WEST SUSSEX COUNTY COUNCIL CONSULTATION

TO:	Arun District Council FAO: Anita Gardner
FROM:	WSCC - Highways Authority
DATE:	6 September 2019
LOCATION:	The Body Shop International Plc, Watersmead Business Park, Littlehampton, BN17 6LS
SUBJECT:	LU/221/19/PL A temporary workshop building to be located on car park of main site.
DATE OF SITE VISIT:	n/a
RECOMMENDATION:	Advice
S106 CONTRIBUTION TOTAL:	n/a

Site Plan

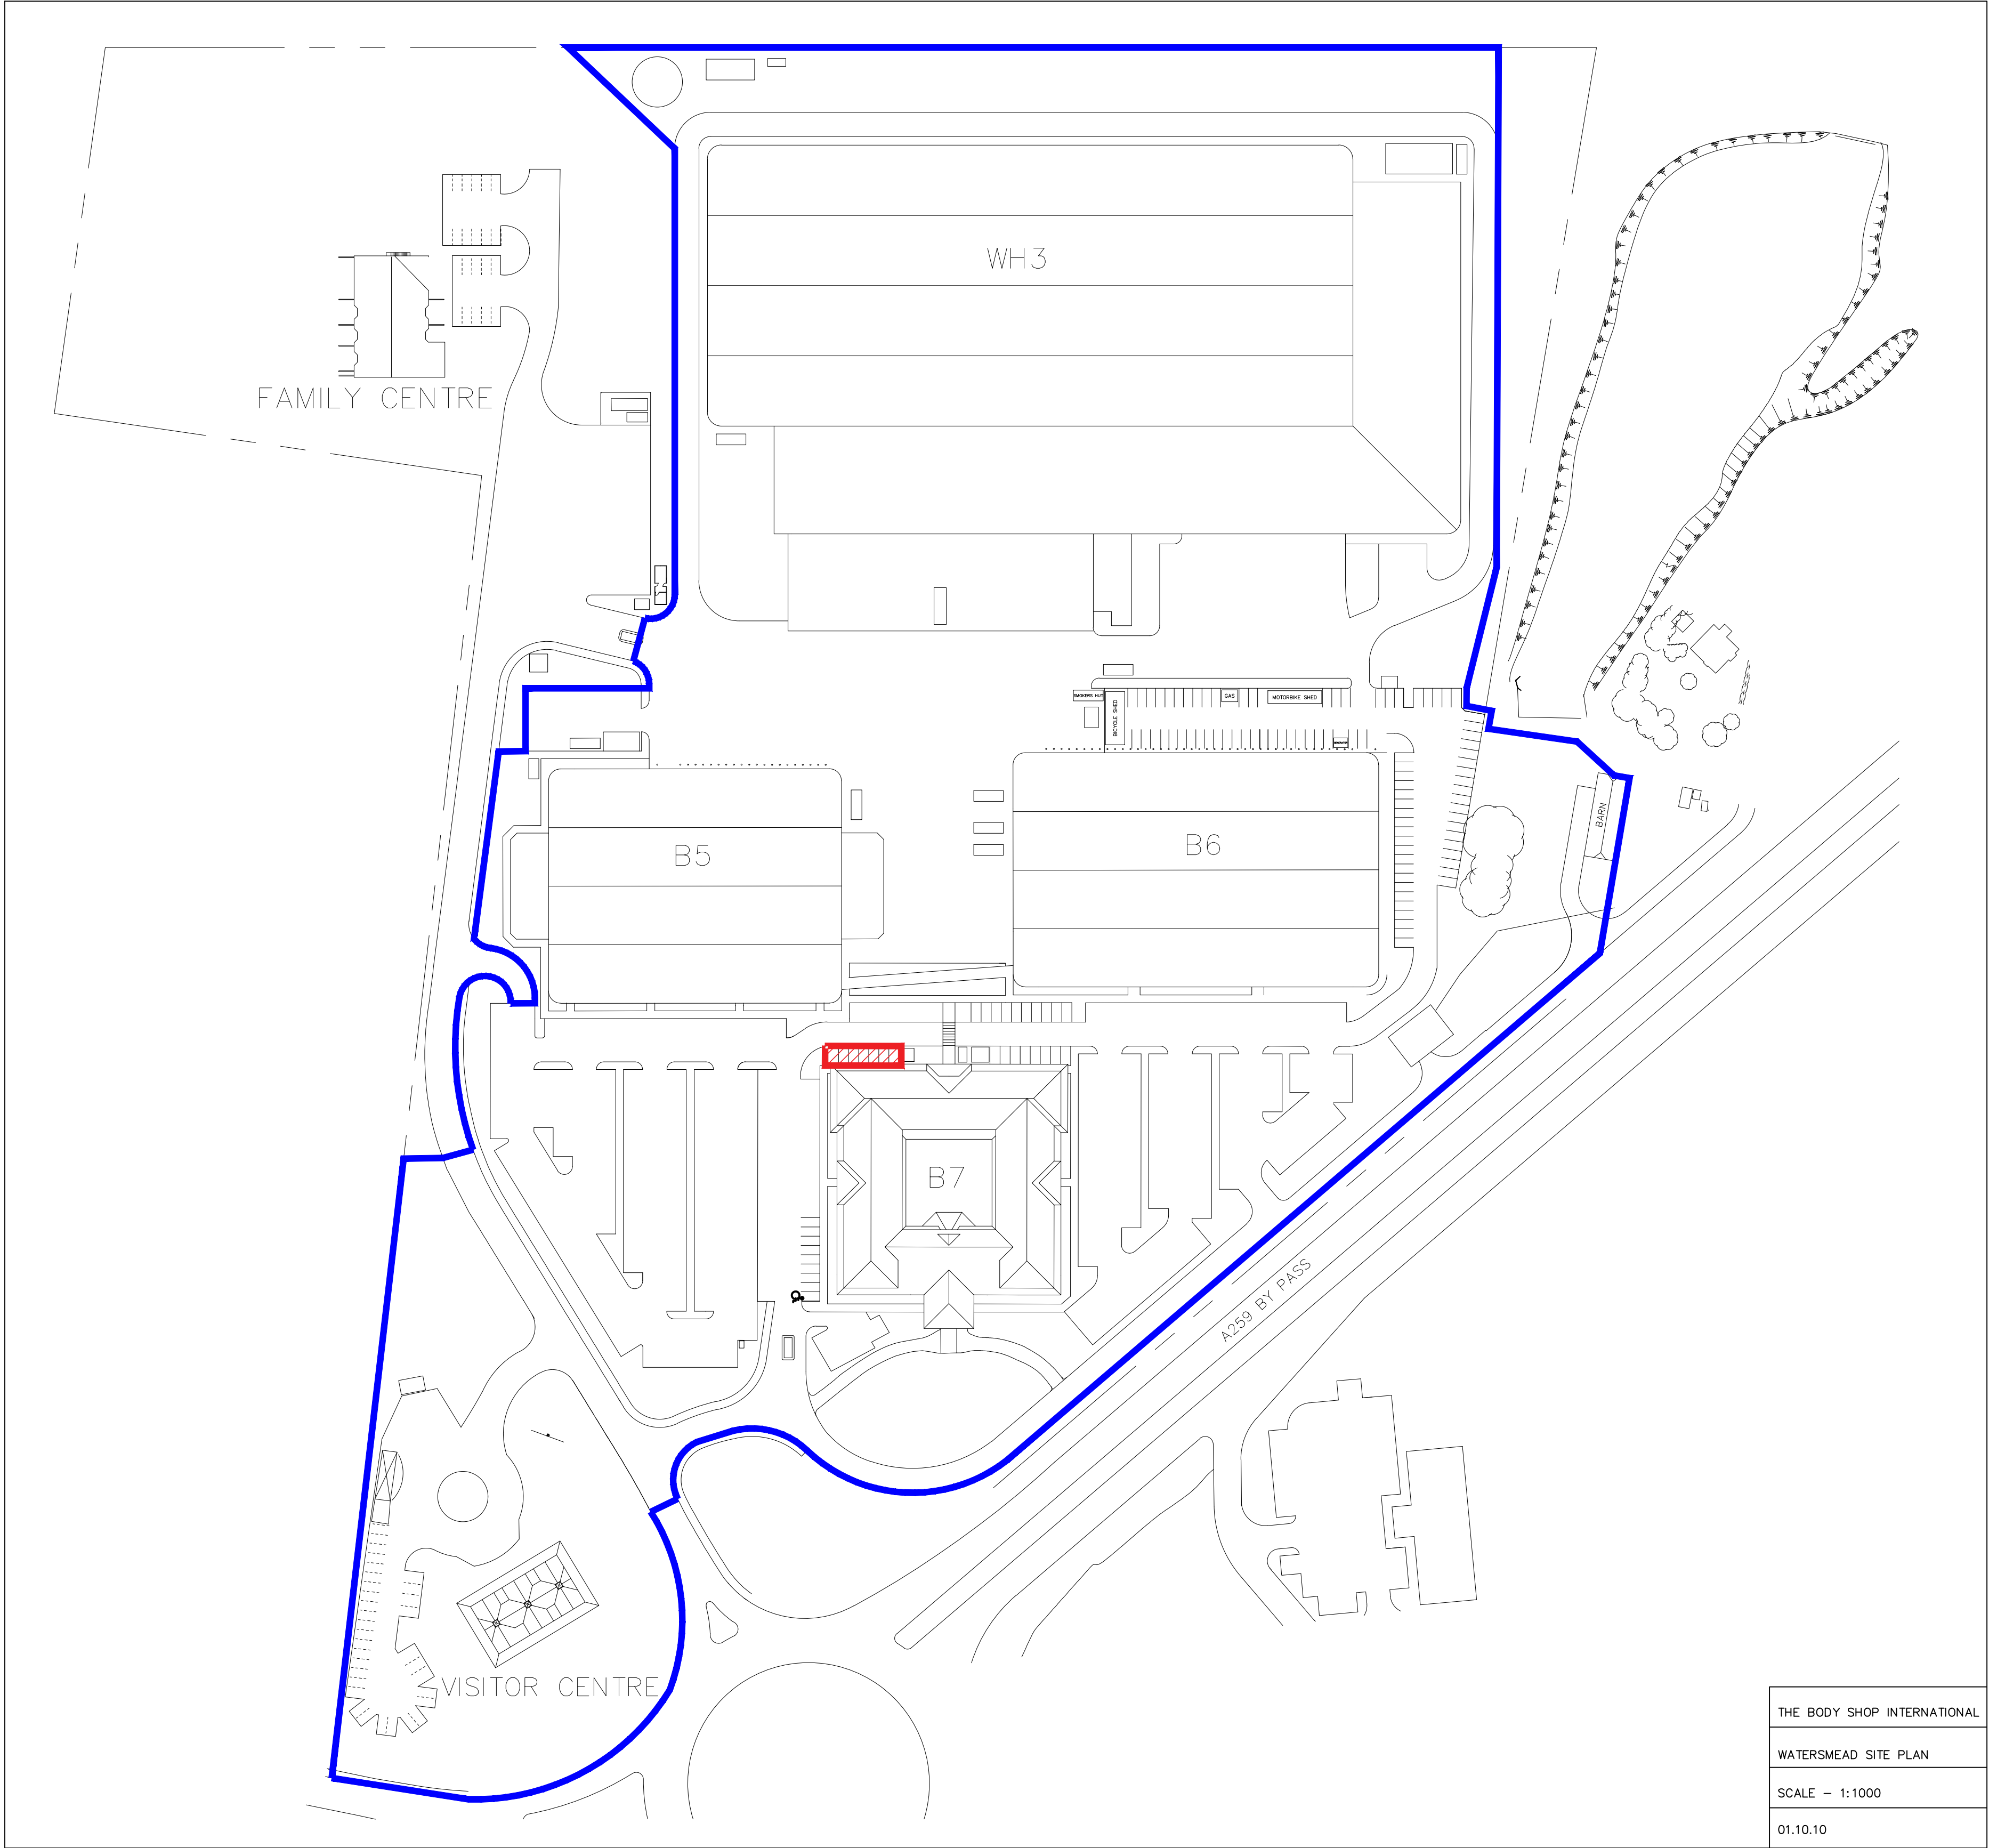
No alterations to the site access arrangements are proposed. The proposed workshop is 78sqm in area, and would result in the loss of 7 parking spaces. Whilst a parking layout plan has not been provided, there would appear to be sufficient remaining parking spaces available to serve the site. The proposed workshop is to be utilised by the on-site maintenance team and as such is not anticipated to result in an increase in parking demand, nor an intensification of use of the existing site access.
